**Subject:** RE: Application Ref: LU/164/19/PL - 5 Arundel Road, Littlehampton

We hereby submit a response to the matters raised in the Environmental Health team's consultation response dated 12<sup>th</sup> July 2019.

This document has been prepared following comments from Environment Health at Arun District Council received by WYG on 15<sup>th</sup> July 2019.

Studio Lack Architecture Studio Lack Ltd : 17 Beech Avenue : Chichester 01243 782 686 : nicholas.lack@live.com : PO19 3DR	5 Arundel Road, Littlehampton	Proposed Elevations 30/03/19 1/100 @ A3	Dwg 1915-07C
--	--	---	---------------------

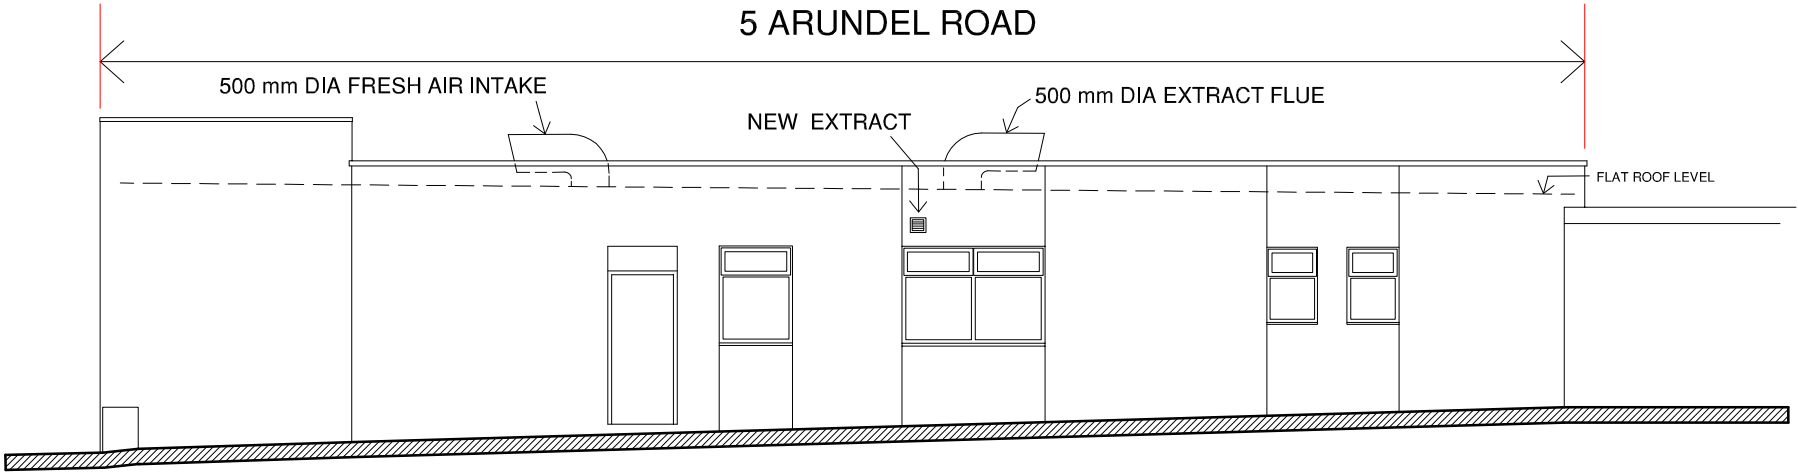
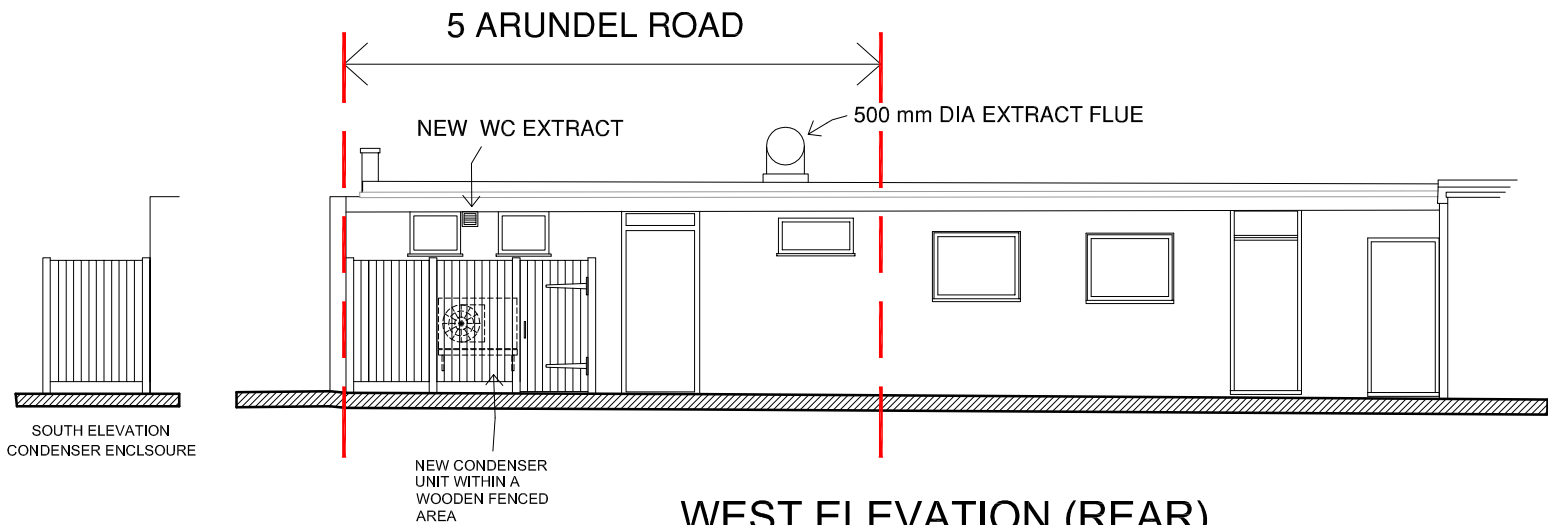
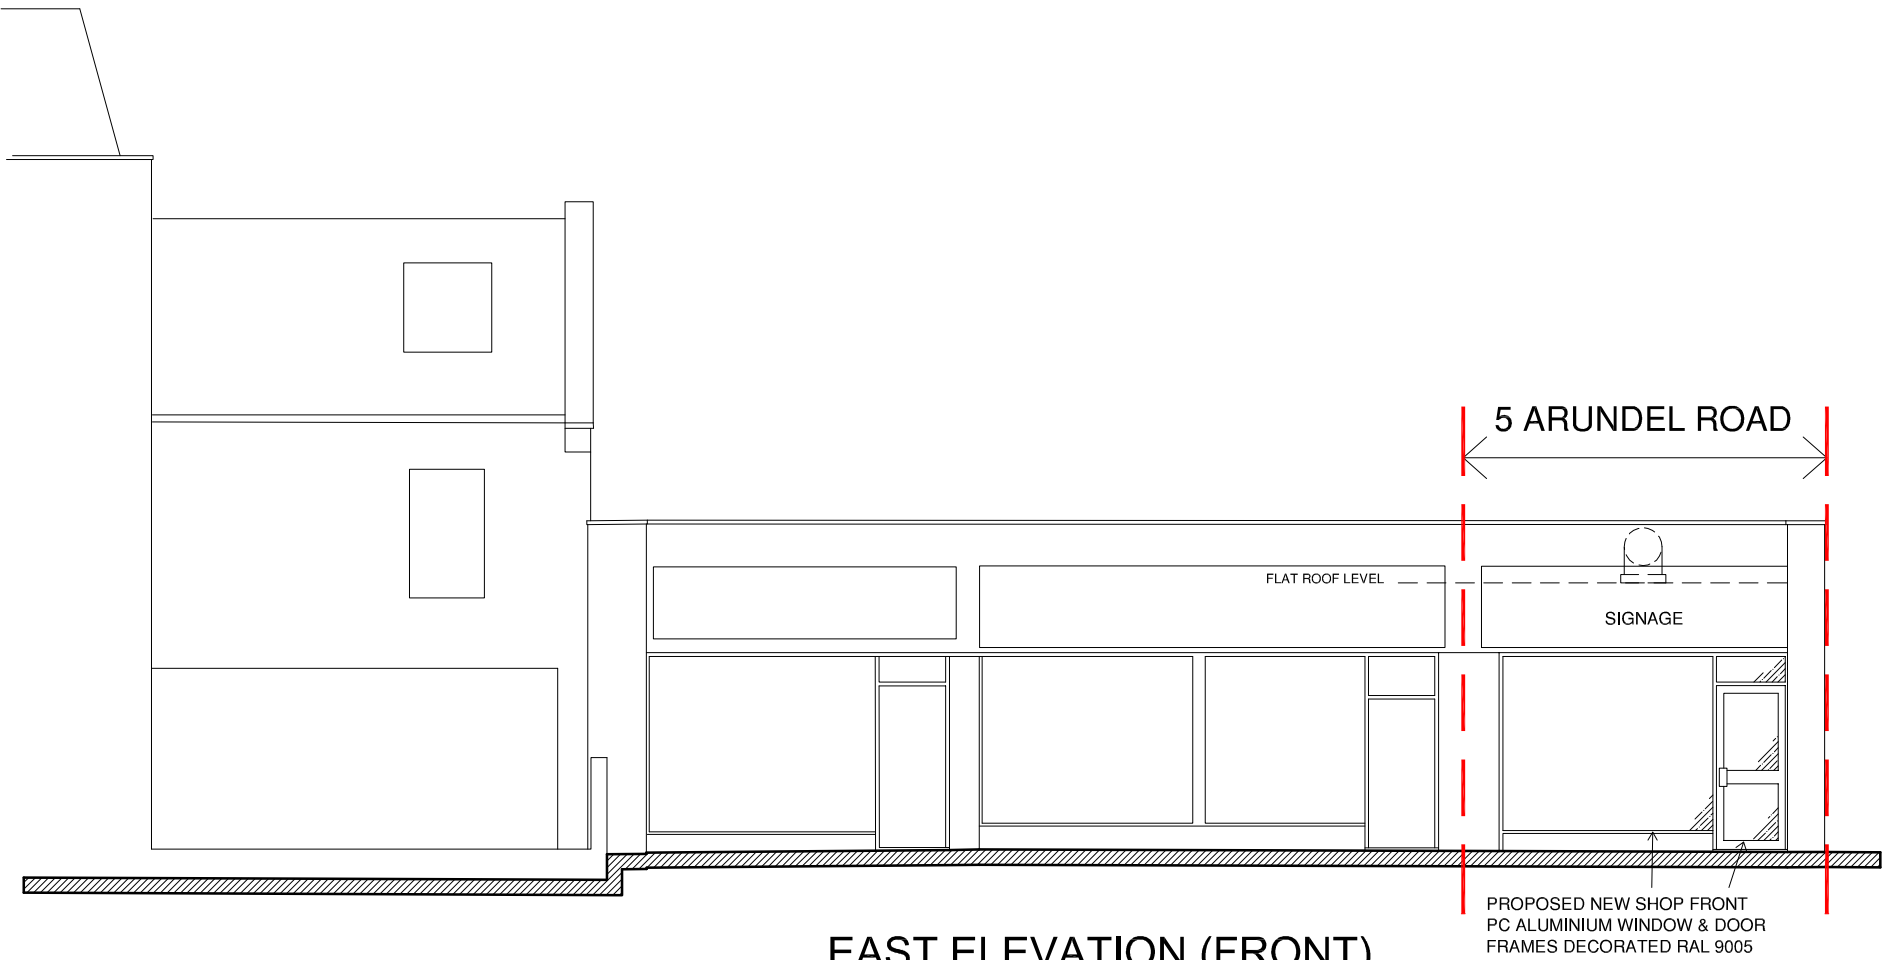
Unfortunately this report only considers noise from the condenser unit to the walk in chiller, whilst excluding other new noise sources particularly in respect of noise from the air intake and exit flue to the flat roof of this single storey building above the kitchen odour abatement system, but also extract ventilation to the kitchen sinks. Please would you request that the applicant also provides proper assessment of these areas, together with detail of any further mitigation measures that may be necessary

*Unfortunately this report only considers noise from the condenser unit to the walk in chiller, whilst excluding other noise sources particularly in respect of noise from the air intake and exit flue to the flat roof of this single storey building above the kitchen odour abatement system, but also extract ventilation to the kitchen sinks. Please would you request that the applicant also provides proper assessment of these areas, together with detail of any further mitigation measures that may be necessary.*

Any potential noise associated with the air intake and exit flue to the flat roof will be a result of an inline fan located within the shop/building structure. The fan is proposed to be a 'Woods ESTOC 50-355-3'; the product data sheet is appended to this document which presents the following noise level data:

This noise level is more than 10 dB below the 'Glendon Karbox 2464' condenser unit of 56 dBA at a 1m distance (46 dB when normalised to 3m), assessed within the original noise assessment. Noise breakout from the proposed extraction fan is more than 10 dB quieter than the externally mounted condenser unit and therefore would make a negligible contribution to overall noise levels.

Furthermore, the noise level presented within table 1.0 above does not include any additional attenuation provided by extract ductwork or attenuation from the building envelope itself. As such, noise breakout from the extract system would be even lower, and the conclusions of the noise assessment would not be affected.

For the extract ventilation to the kitchen sinks, it is understood that this unit will be a standard wall mounted extract fan, the type is similar to those used within domestic bathrooms with timer, which will result in little or no externally generated noise. It is understood this will be a 'Vent-Axia VASF100'. A datasheet has been appended which shows a sound pressure level of 28 dB(A) at a 3m distance at high speed. Given the closest dwelling façade is more than 10m away from the location of this unit, it would make a negligible contribution to overall noise levels.

It should also be noted that the applicant will be sealing closed the existing opening windows, further reducing the potential for any noise breakout from internally located building services plant to outside areas or surrounding sensitive receptor locations.
